Rezoning Transportation Analysis

Petition Number: 2022-209

Date	Description
4-27-23	First Review (PDM)
5-24-23	Second Review (DR)

The site is located adjacent to Morehead Street, a State-maintained major throughfare and south of McDowell Street, a State-maintained major throughfare. A Traffic Impact Study (TIS) is required for this site due to the site's trip generation and location along a high injury network roadway. Site plan and/or conditional note revisions are needed to complete the Traffic Impact Study. Further details are listed below.

RZ 1.0

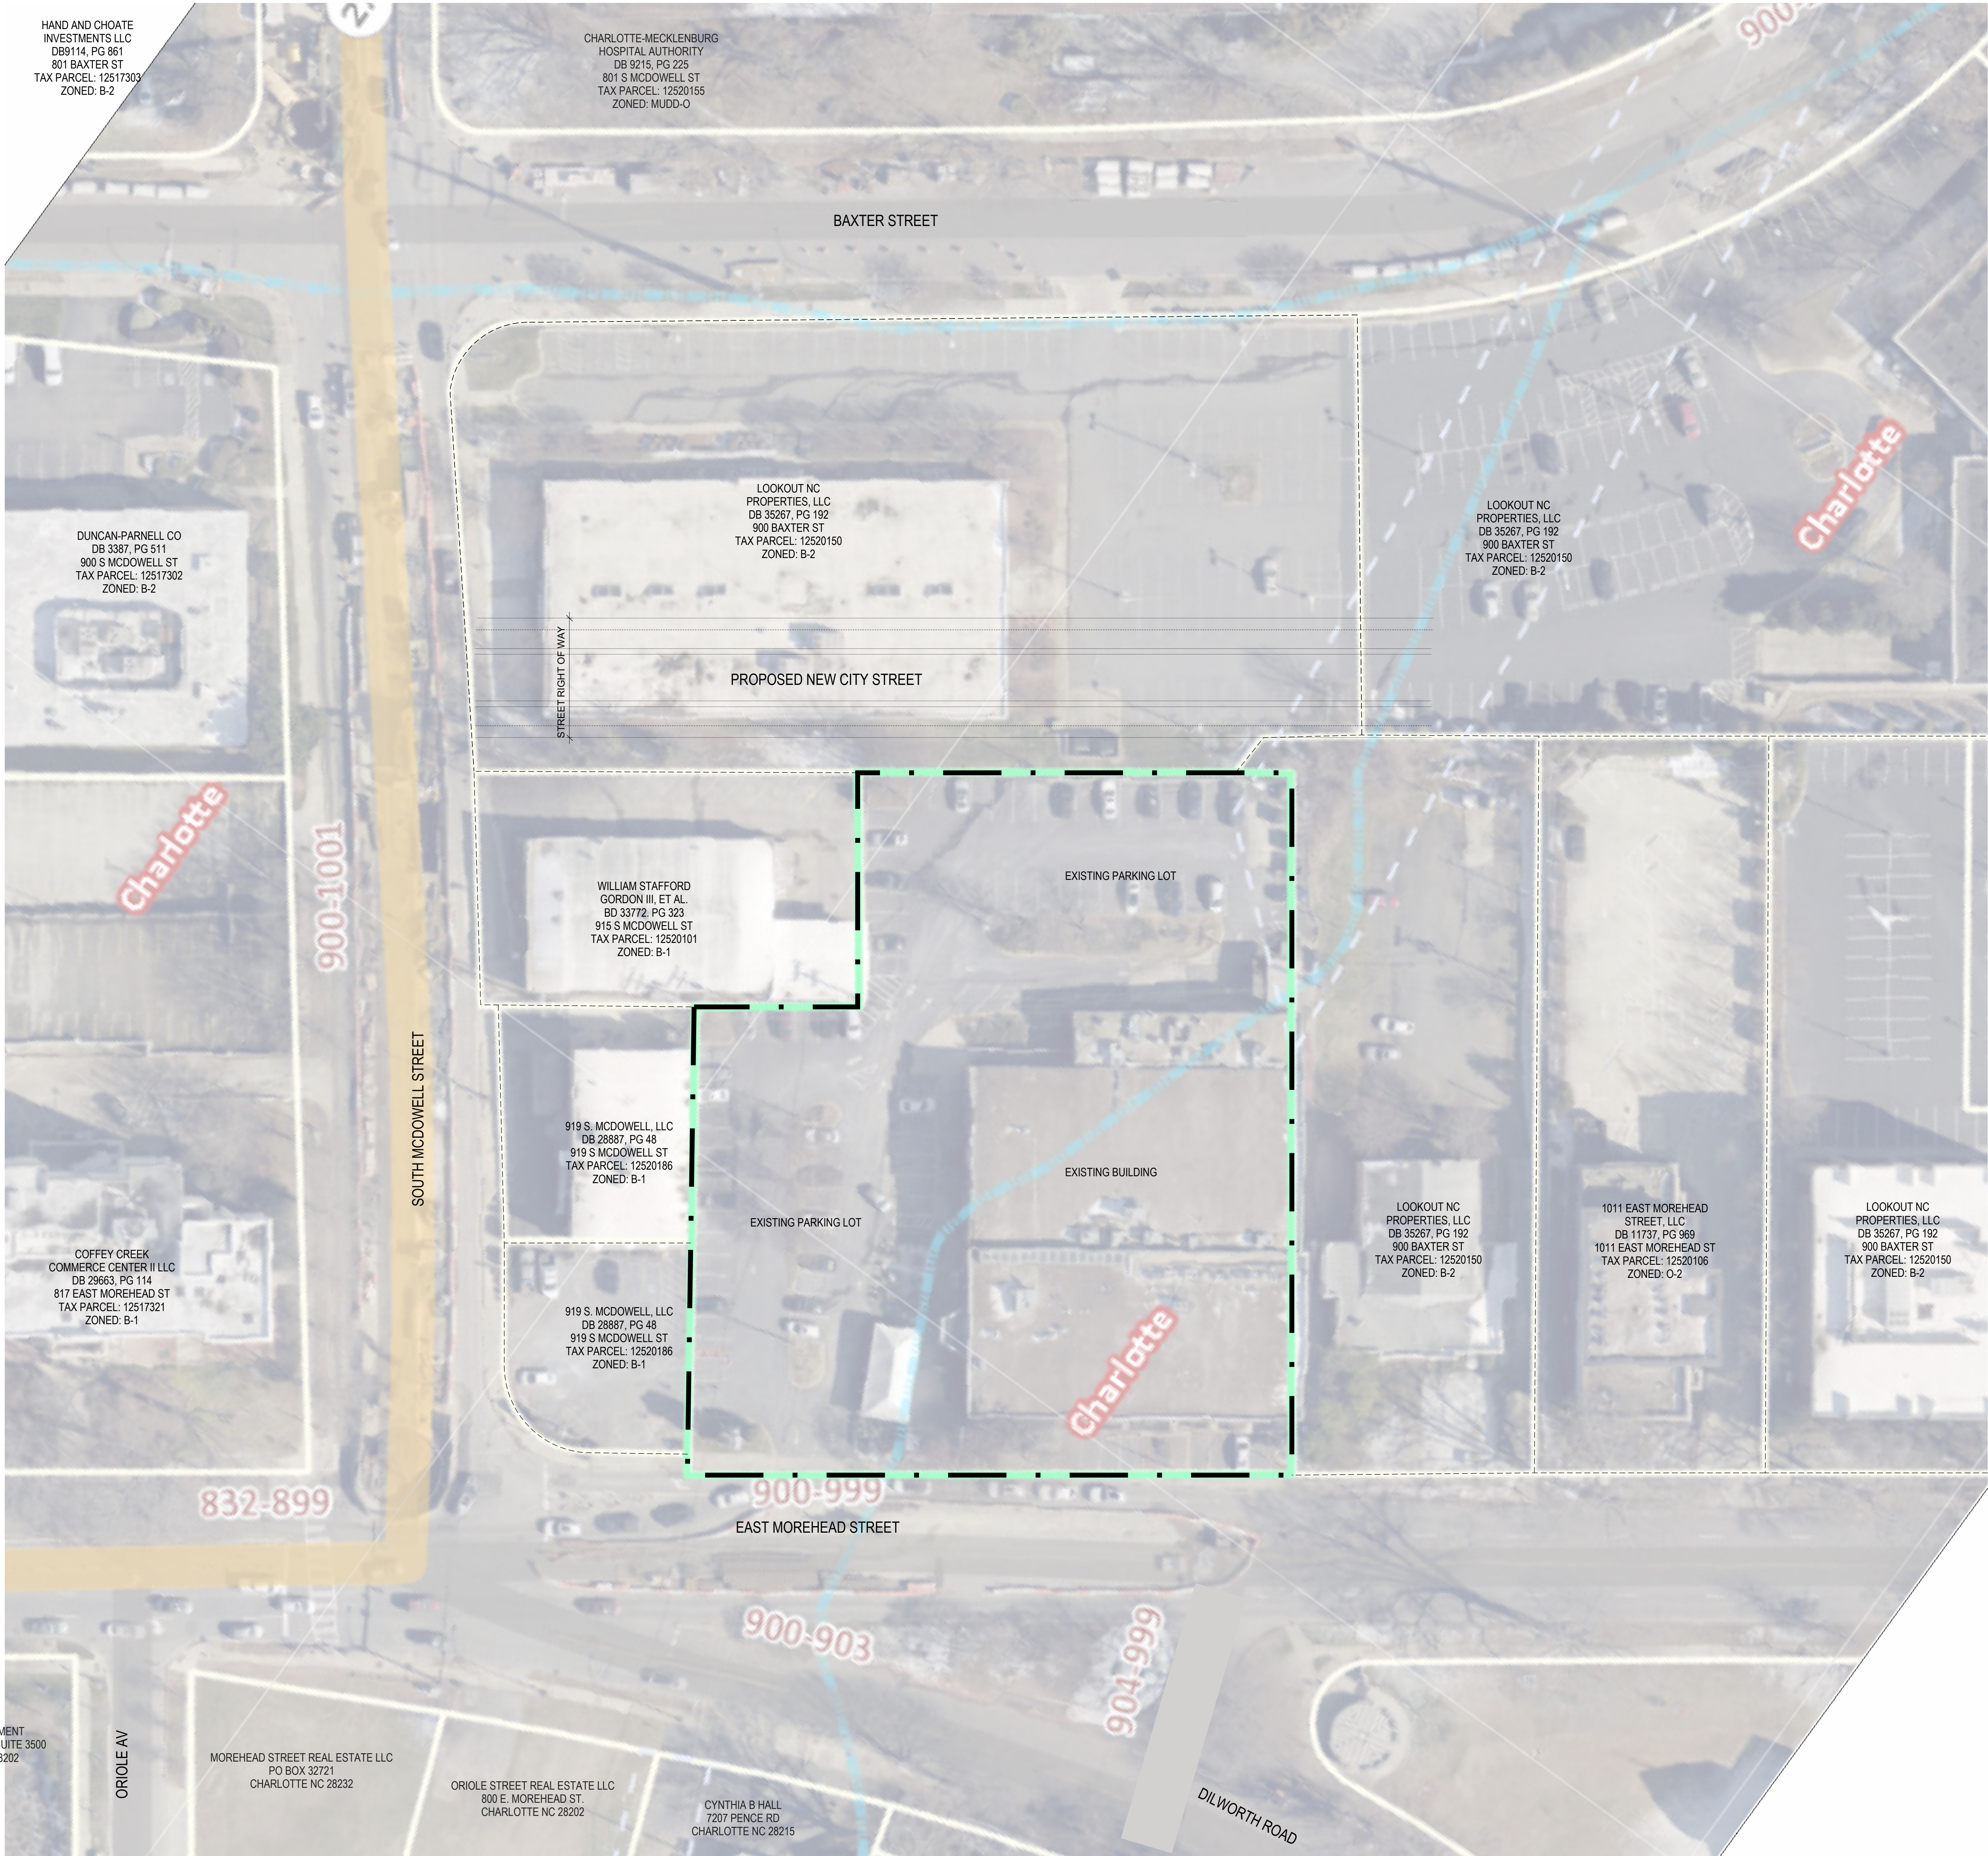
1. ~~Curblines:~~

~~**Morehead Street:** Location of curb and gutter to be moved to 38 feet from roadway centerline to accommodate the Charlotte Streets Map with a roadway typical section of a four plus avenue with buffered bike lanes.~~

~~Label and dimension the curb and gutter from the centerline for each road on the site plan.~~

2. Traffic Study:

A Traffic Impact Study is required for the complete review of this petition due to the site being located along a high injury network roadway.

Outstanding Comment 5.24.2023: Awaiting TIS submittal and petitioner is working with CDOT to finalize scope.

- ~~3. Revise site plan and conditional note(s) to commit to dedicate a minimum of 40 feet of right of way from the road centerline. The site plan shall label and dimension the right of way from the road centerline. In addition, provide sidewalk utility easement if the proposed sidewalk facility will be located outside of the ROW.~~
- ~~4. Revise site plan and conditional note(s) to extend the existing concrete median along Morehead to the Dilworth Road connector.~~

- ~~5. Revise site plan and conditional note(s) to commit to construct an 8-foot planting strip, and 8-foot sidewalk on Morehead Street per Chapter 19. The site plan shall label and dimension both items from the back of the future curb and gutter location.~~
- ~~6. Revise site plan and conditional note(s) to clarify who is constructing the offside proposed street, and that a cross access easement is required to access the street across private property.~~

- ~~7. Revise site plan and conditional note(s) to commit to construct bicycle facilities by locating the curb and gutter 38 feet from the center line to meet the Council-adopted Charlotte BIKES Policy.~~
